Dear Amy,

Thank you for reconsulting us on this application. The information submitted is insufficient to avoid the need for pre-commencement conditions.

Attenuation tank using polystorm-r geomodular units trafficked areas

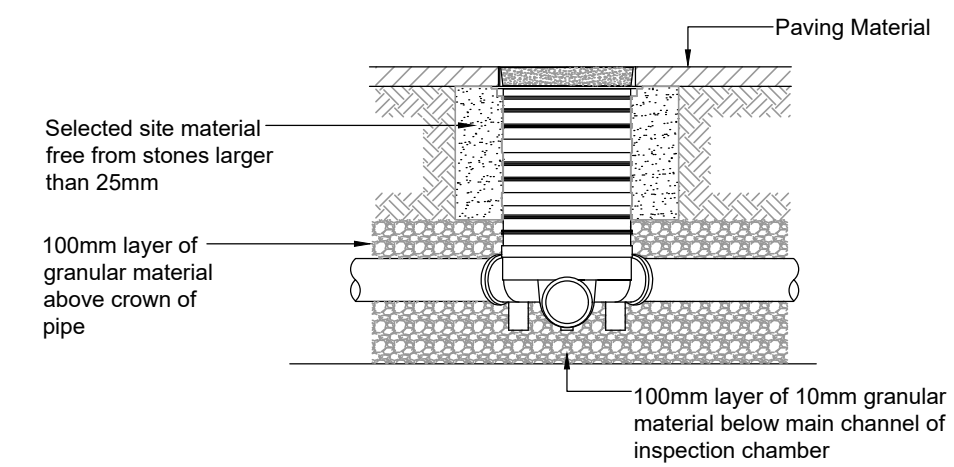
3. The calculations supplied do not include details of impermeable areas, the attenuation tank modelled or the flow control modelled. These details must be included in printouts to facilitate verification.

ELEVATION OF HEADWALL OUTFALL TO POND / SIDE OF DITCH

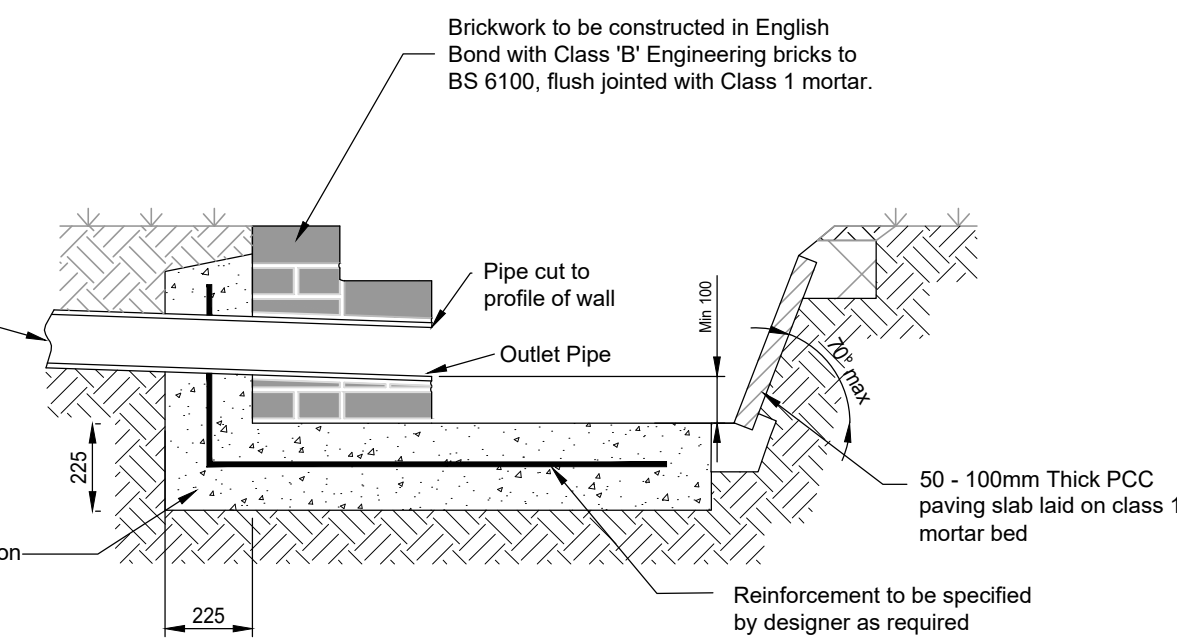
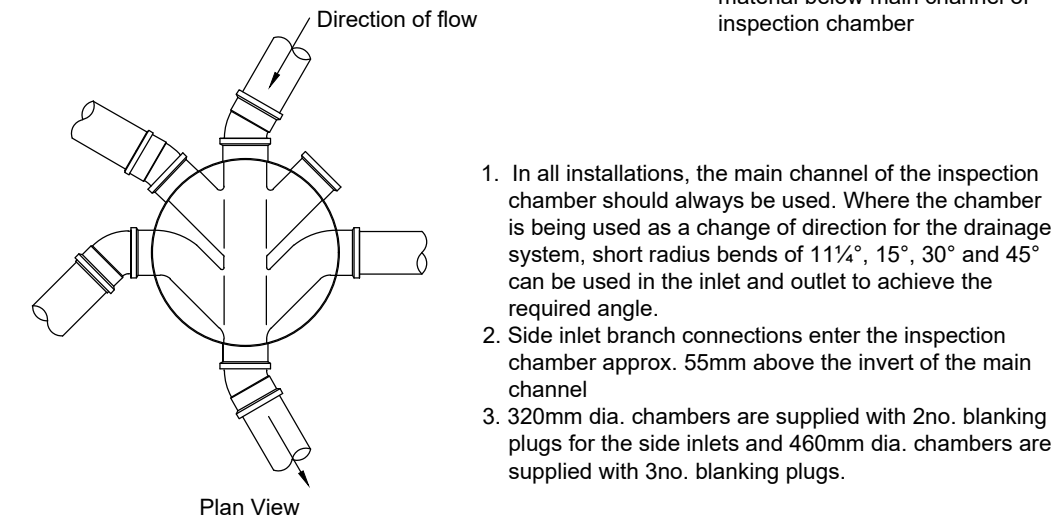
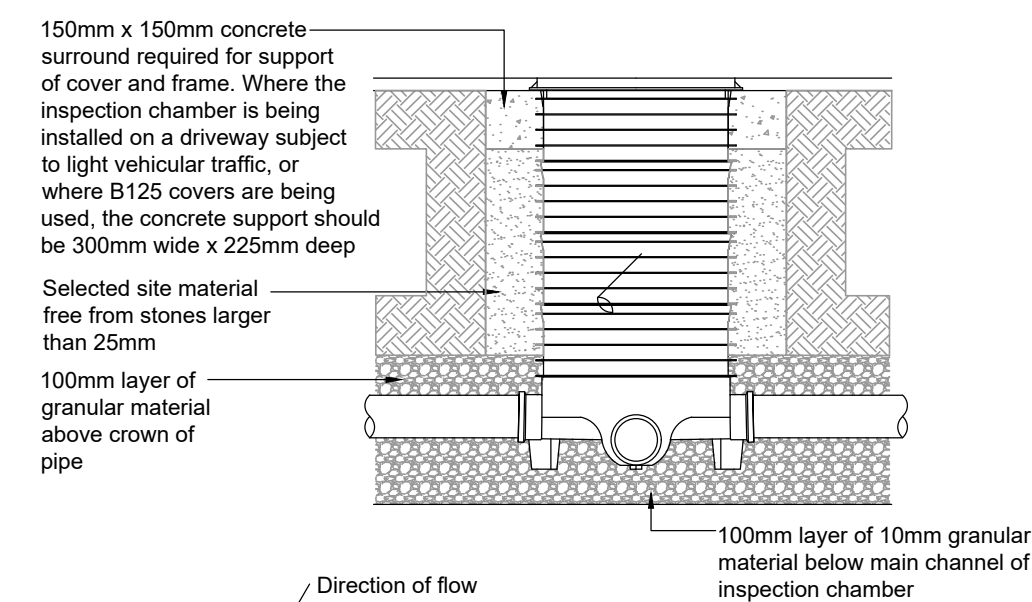
2. The drawing supplied shows a proposed connection to ordinary watercourse against the direction of flow, an alternative connection location is required.
